# KITTITAS COUNTY

**TO:** All Staff  
**FROM:** Public Works Plan Review Team  
**DATE:** September 28<sup>th</sup>, 2023  
**SUBJECT:** Public Works Comments: BL-23-00018 Pendley

PENDLEY PROPERTY

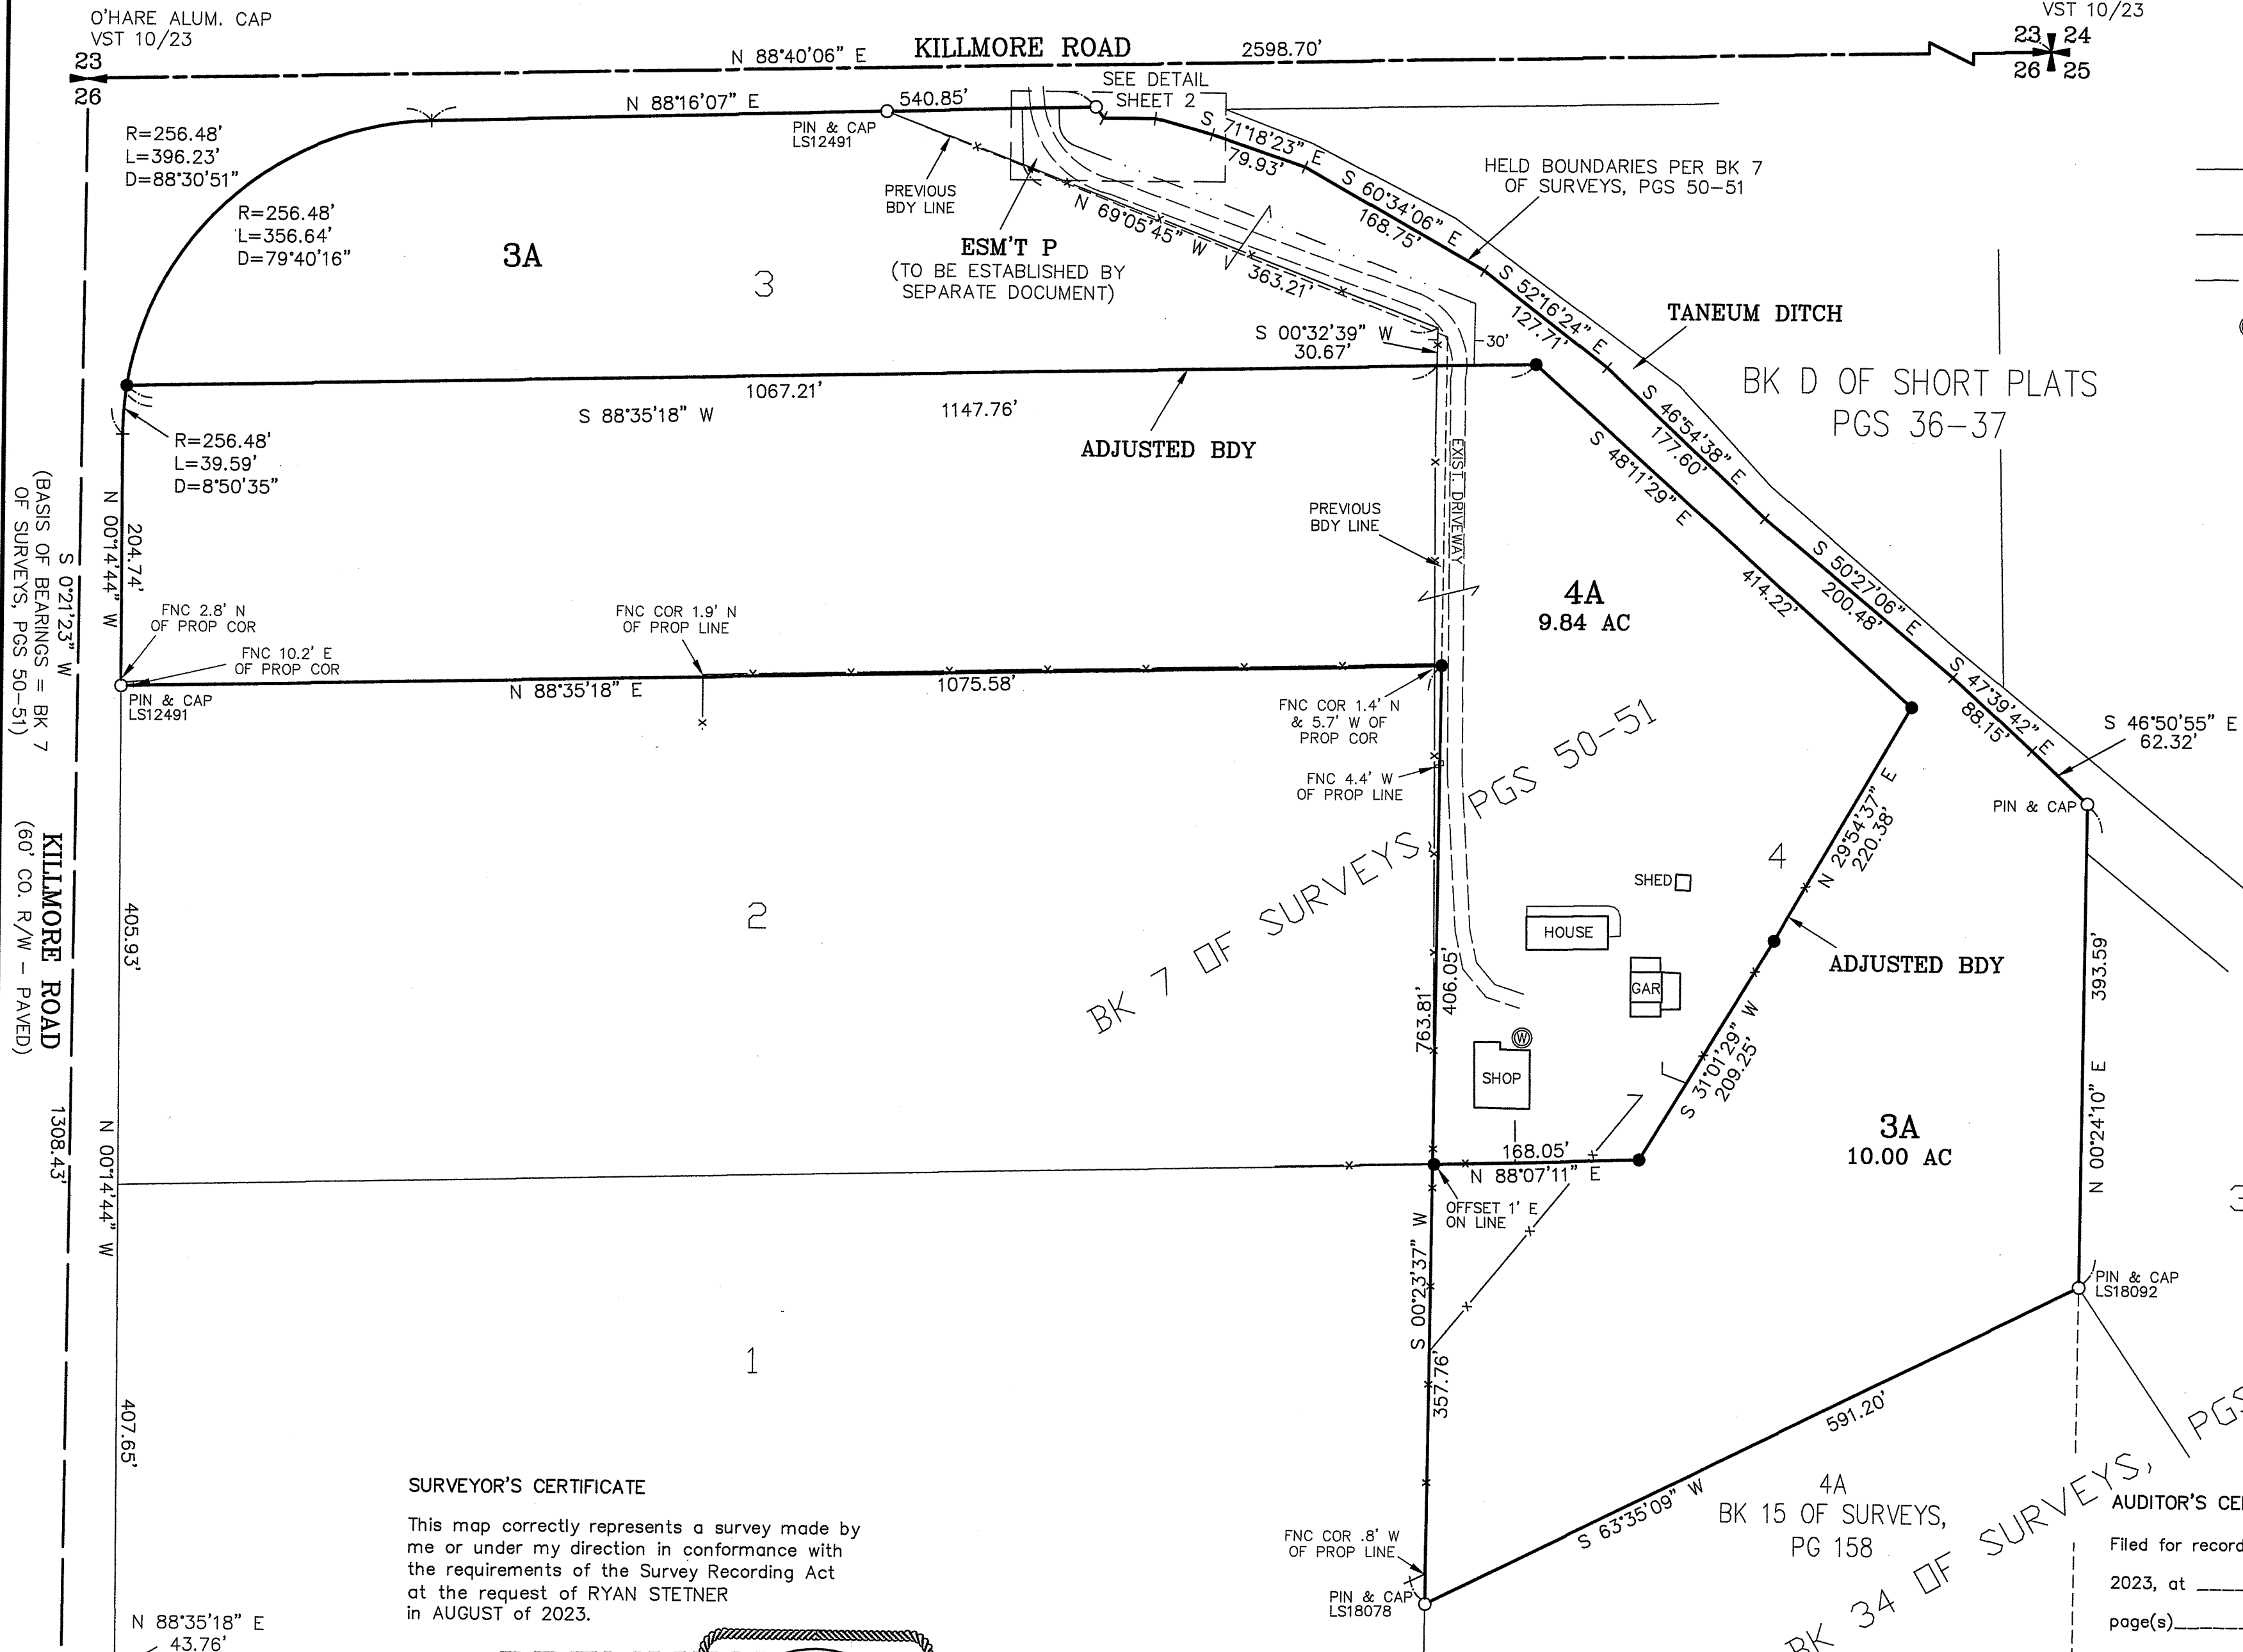
<p><b>SURVEY</b></p>	<p>As the application does not contain a survey map, survey review will be done at final submittal. (JT)</p> <p>UPDATE 11/17/2023          No Changes to the submitted record of Survey required.</p> <p>OF NOTE          The face of the map and the notes reference a different document for the basis of bearing.          The bearing of the North line of Section differs from record data Survey: Bk:7, Pg50. This could be noted.          The “crowsfoot” or “tickmark” located at the E end of the North line of Lot 4A could be made taller to avoid confusion between the two shown distances.</p>
